REQUEST

Current Zoning: N1-A ANDO (Neighborhood 1-A, Airport Noise Disclosure Overlay)
Proposed Zoning: N2-A(CD) ANDO (Neighborhood 2-A, Conditional, Airport Noise Disclosure Overlay)

The petition proposes to redevelop several properties occupied by single-family dwellings with a community of 194 multi-family attached dwellings.

OUTSTANDING ISSUES PRIOR TO PUBLIC HEARING

RZ-1.0

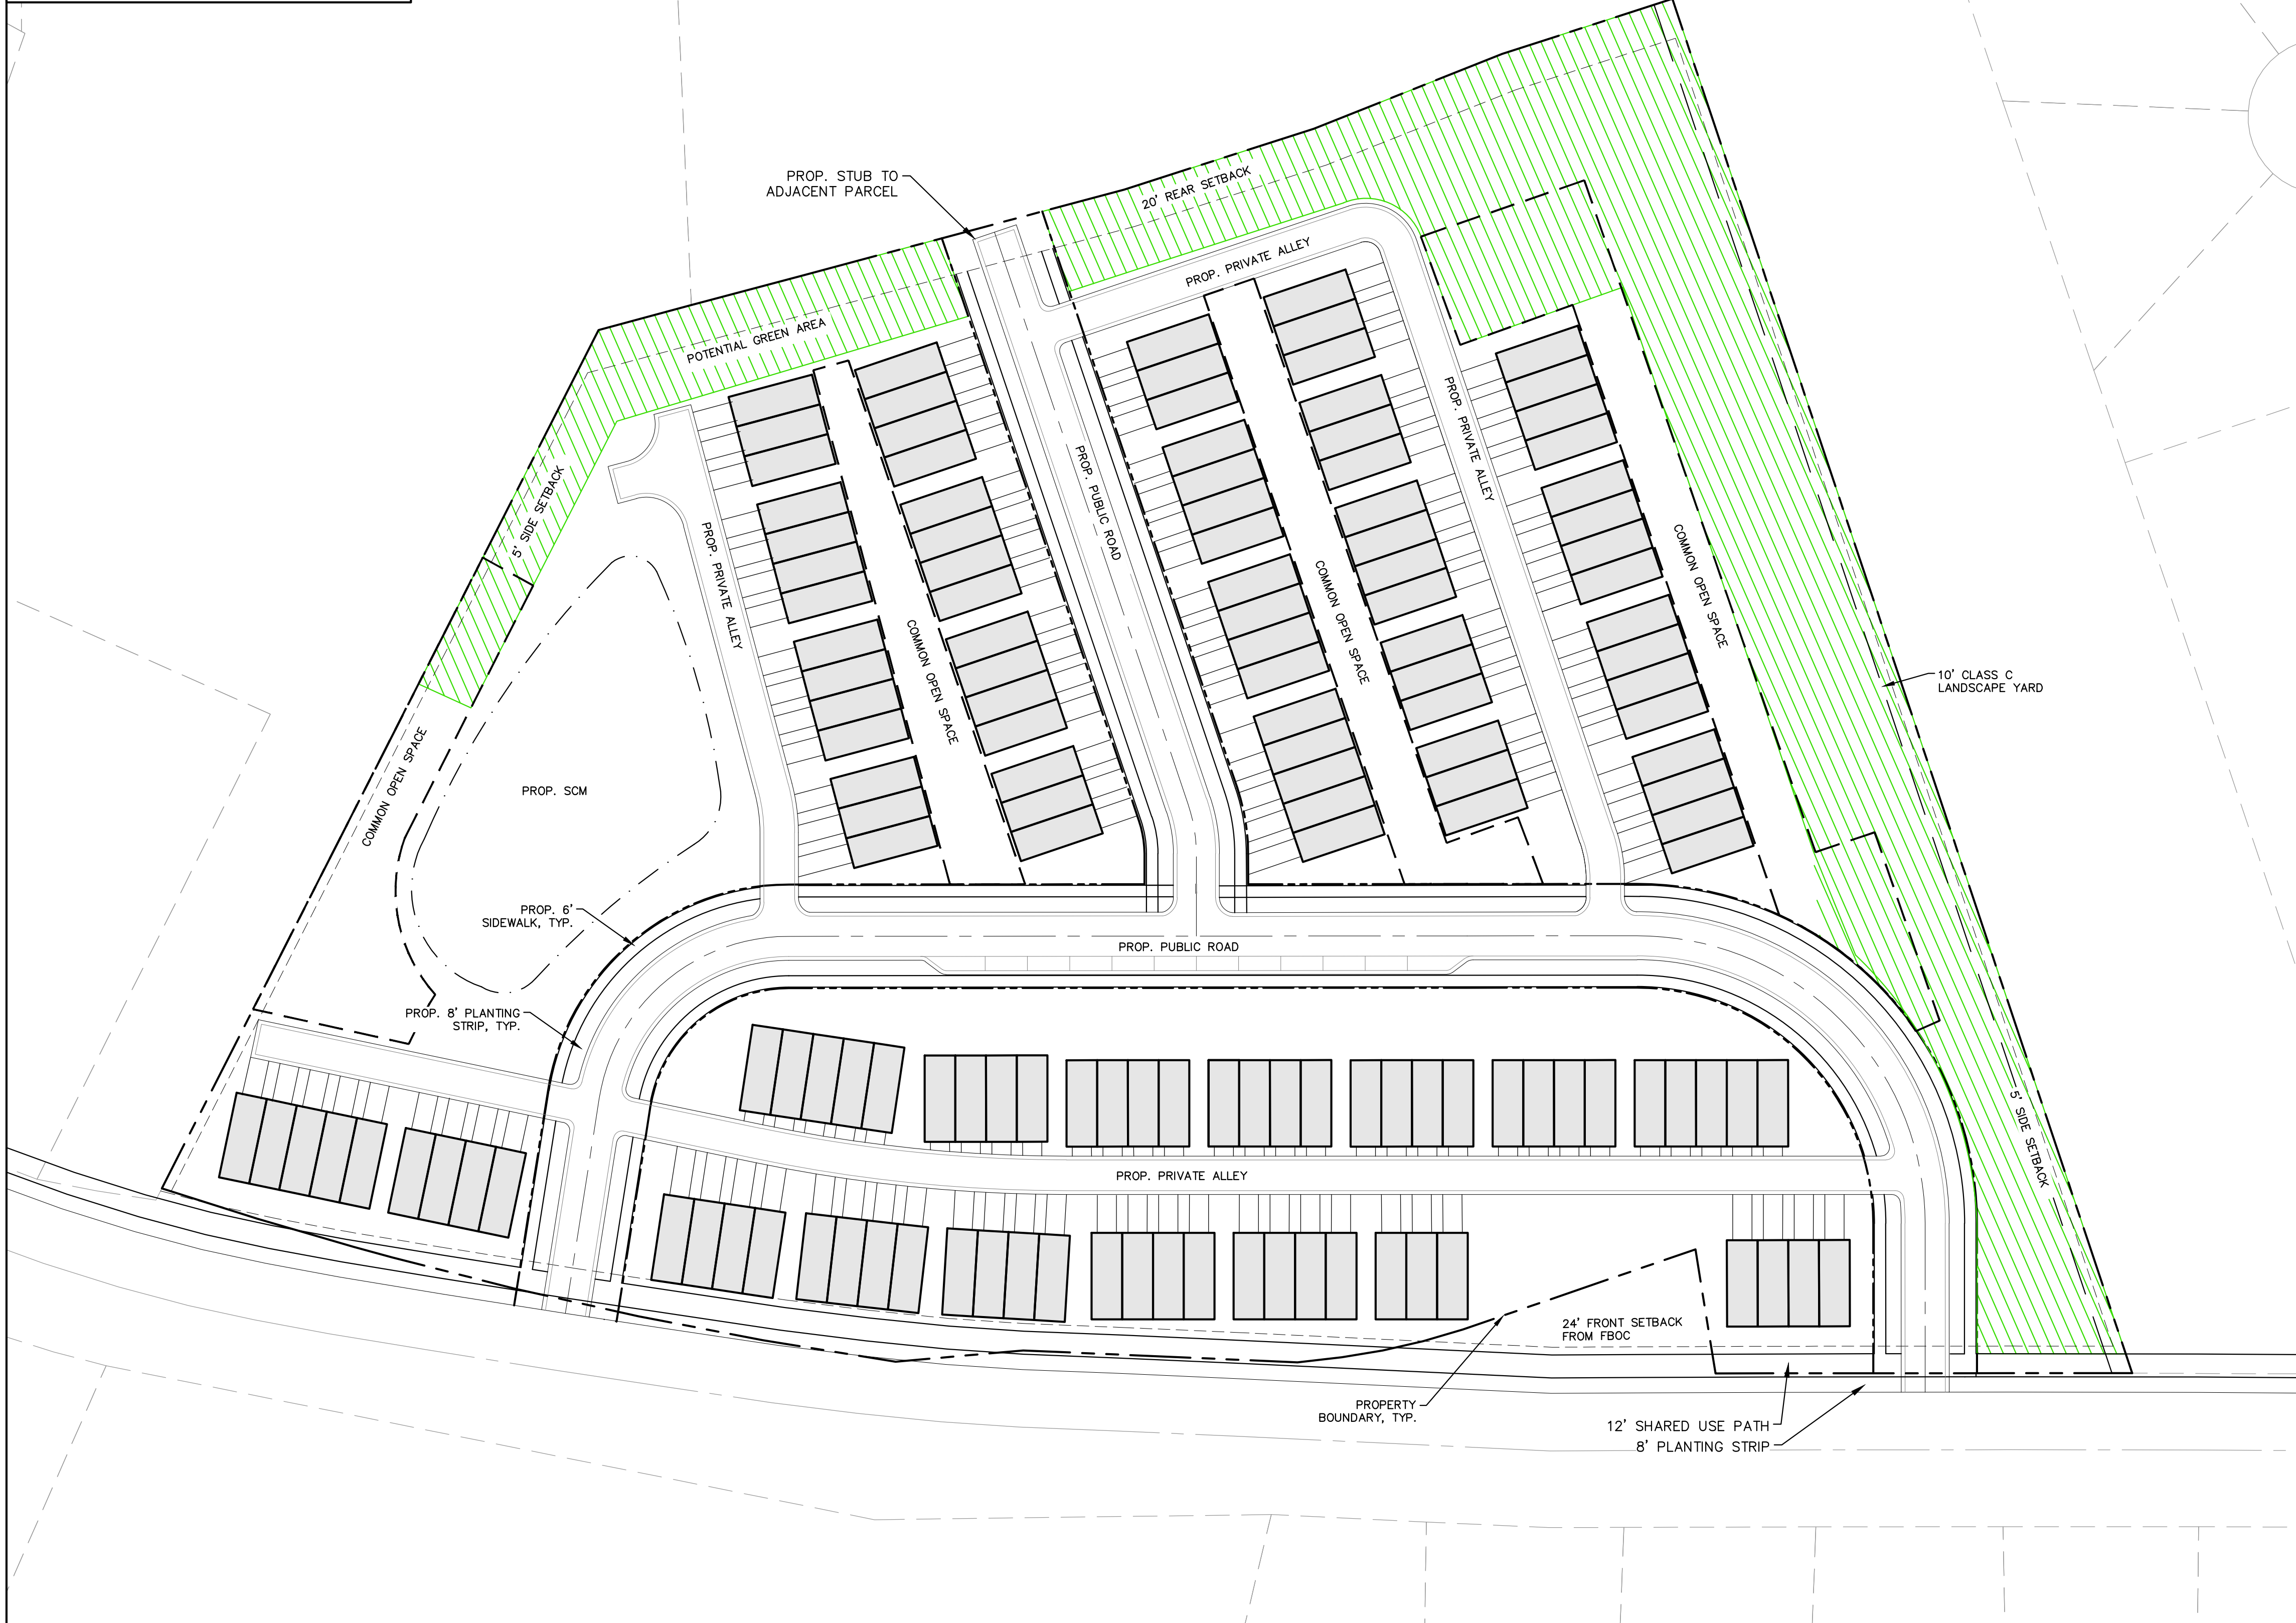
1. ~~Show, dimension, and label in streetscape on all internal public streets. Internal public streets are to be U-03 with 8ft planting strip and 6ft sidewalk and on-street parking. All public streets must have on-street parking where feasible.~~ **ADDRESSED**
2. ~~Revise site plan to modify right-of-way boundaries as illustrated in the CDOT memo.~~ **ADDRESSED**
3. ~~Revise the site plan to show existing edge of pavement and all existing striping on Sandy Porter. Site plan should clearly show lane configurations along Sandy Porter adjacent to the project and how the project will tie-in at either end of the project.~~ **ADDRESSED**
4. ~~Revise Transportation note 11 to correct "rights-of-way" typo.~~ **ADDRESSED**

5. ~~Green area must be comprised of existing tree canopy. Most of the southern area does not have existing canopy or the canopy is from trees on the adjoining property that cannot be used.~~ **ADDRESSED**
